Subject: BR/256/19/PL

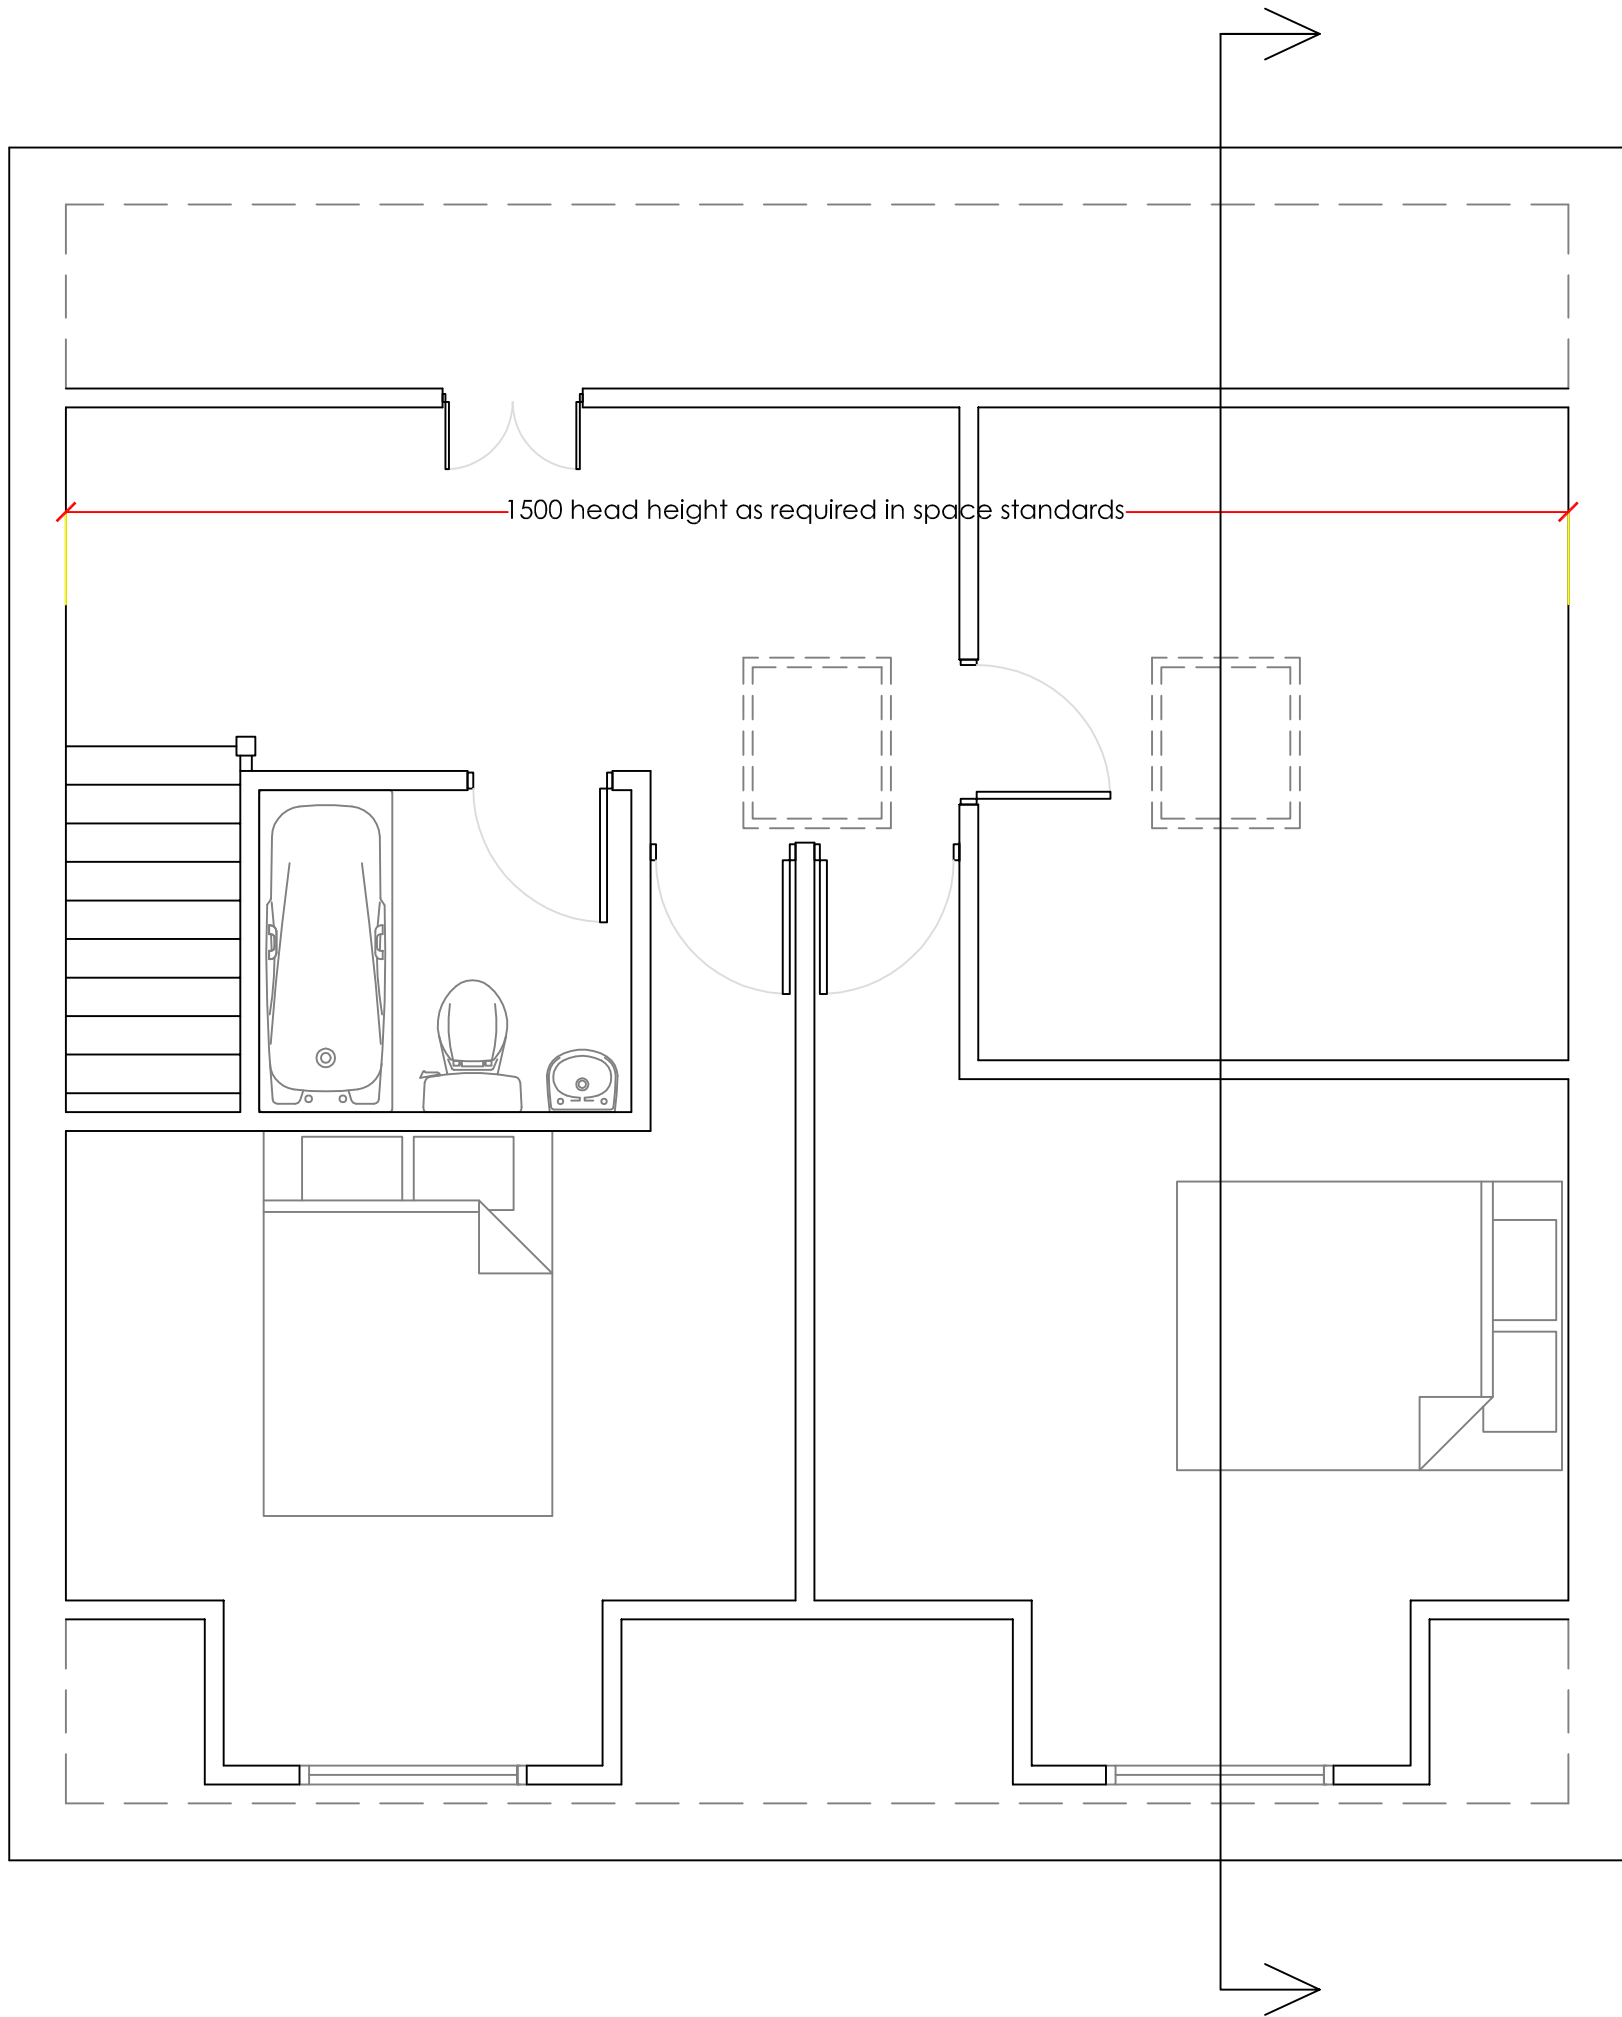
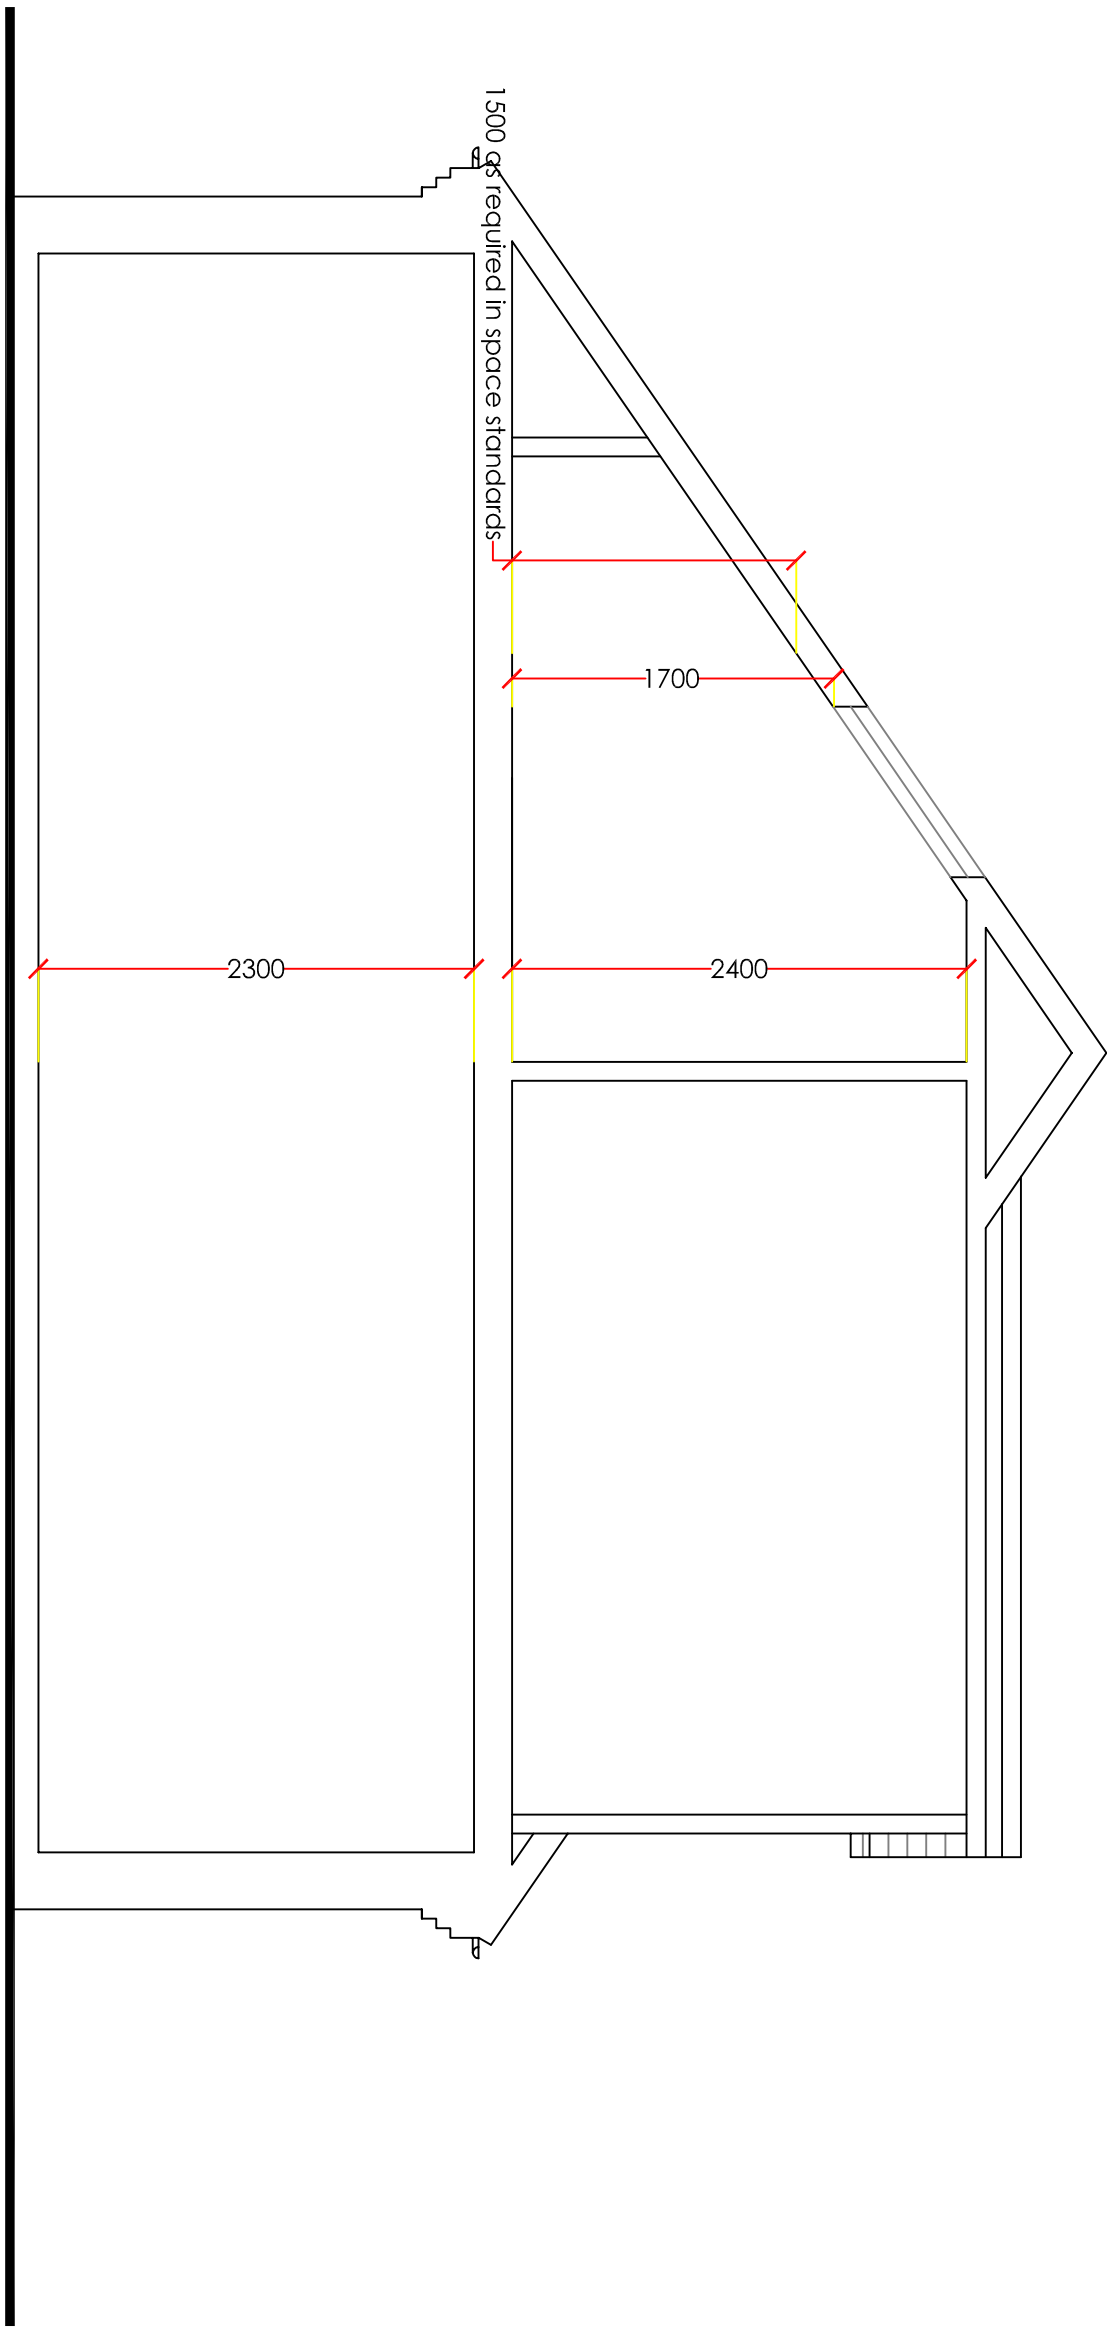
- 1) Could you provide an internal section to show how the pitch of the roof impacts upon internal spaces in the rooms to the rear? I envisage significant concern will be raised given that what is in effect a bedroom is shown to the rear. I will obviously need to assess this as such against internal space standards etc. I also need to be satisfied, through the submission of a section, to ensure the velux rooflights are 1.7m above FFL to overcome issues of overlooking etc...

I note that Simon has requested internal sections of the building to satisfy concerns relating to internal heights – I would be grateful if these could be provided as soon as possible?

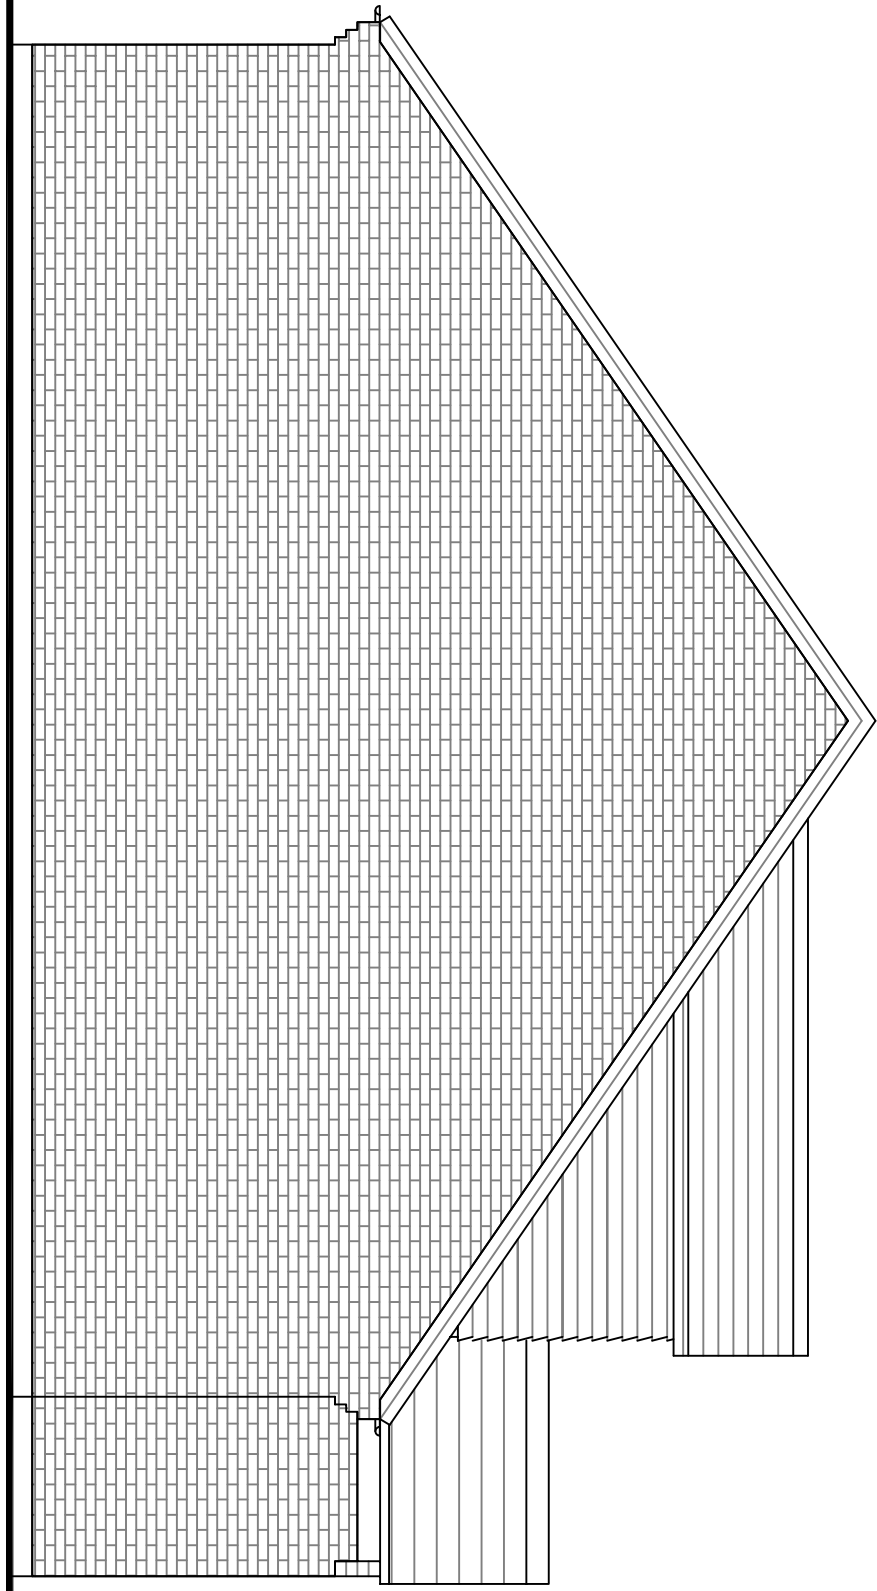
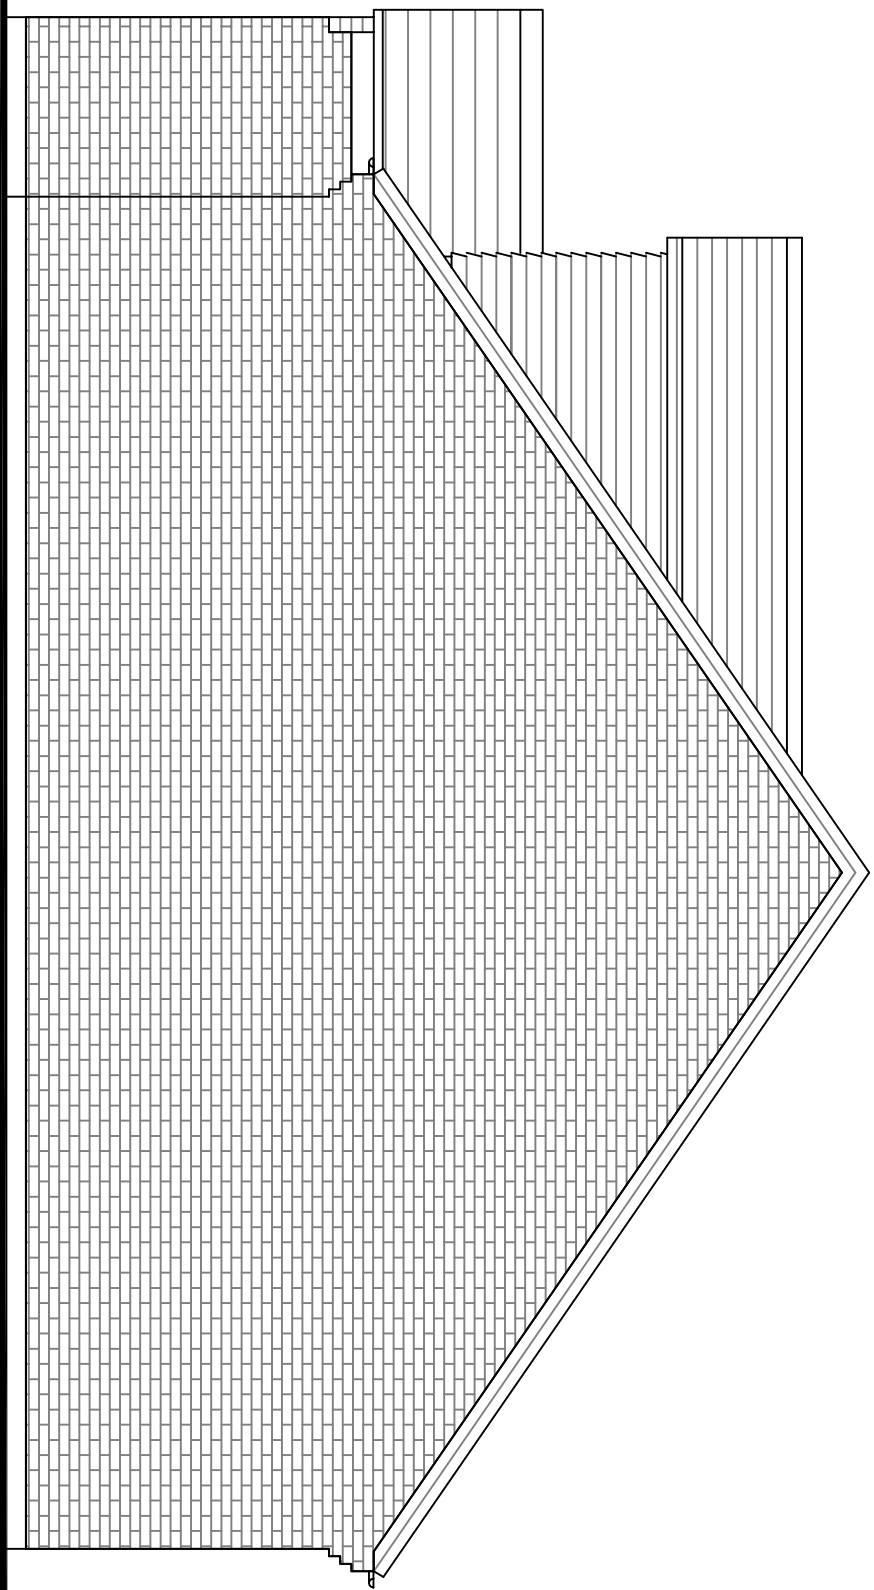
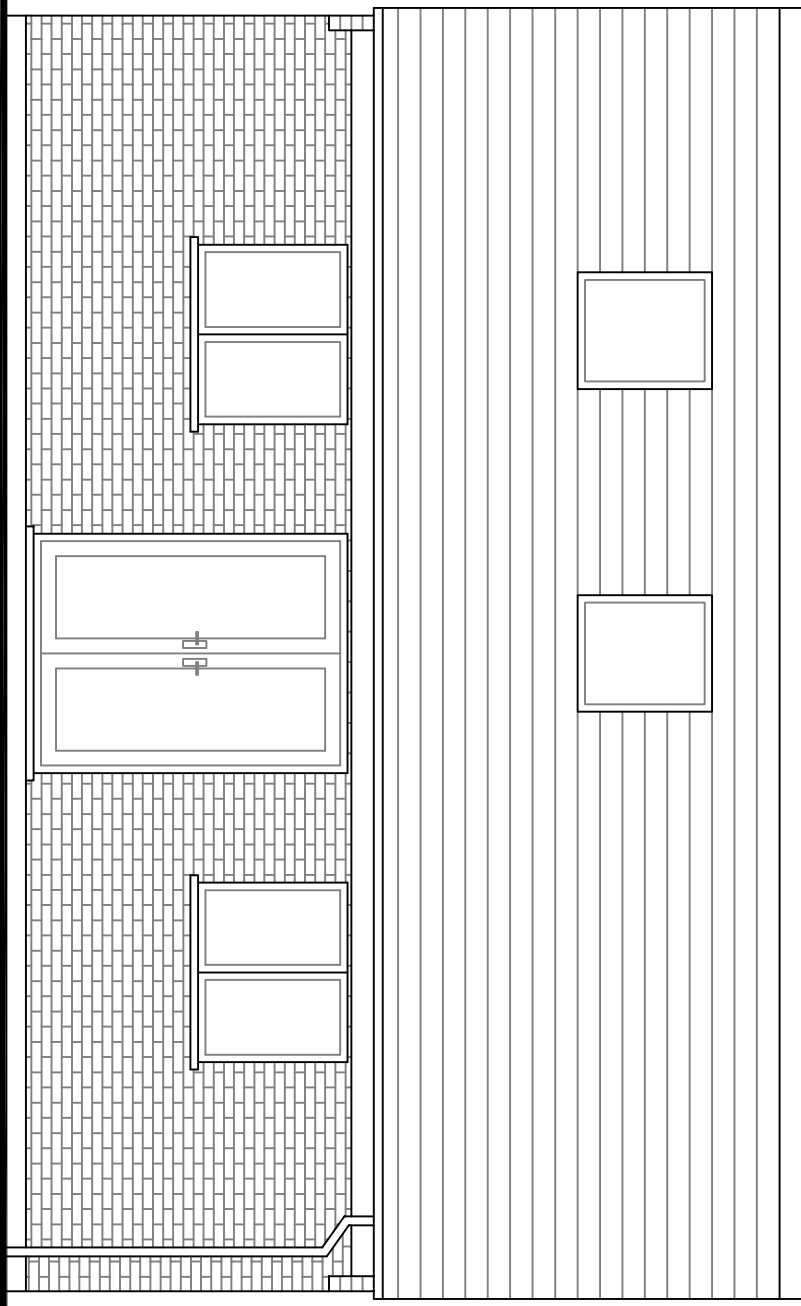
Many thanks for bearing with me over the weekend whilst I took the time to discuss the proposals with my management and Simon. In terms of the submitted 3 bedroom design, and owing to the previous planning histories on the site dating back to 2011, we would have concerns with the rear dormer window and it's proximity to the property to the south, combined with the potential for over massing impacts. Further, we would also have concern relating to privacy deriving from overlooking to the rear garden spaces of properties to the south. Whilst I appreciate that this is somewhat disappointing news, it is with regret that we would be unable to support the application in its current form.

I noted from our previous email correspondence your desire to work with the Local Authority to achieve a development on this site. Having discussed possibilities with management, we would be happy for you to remove the rear dormer window and utilise velux style rooflights, positioned 1.7m above FFL. This would result in a reduction in bedrooms from 3 down to 2. This would provide a development of kinds on the site, which would overcome the concerns raised.
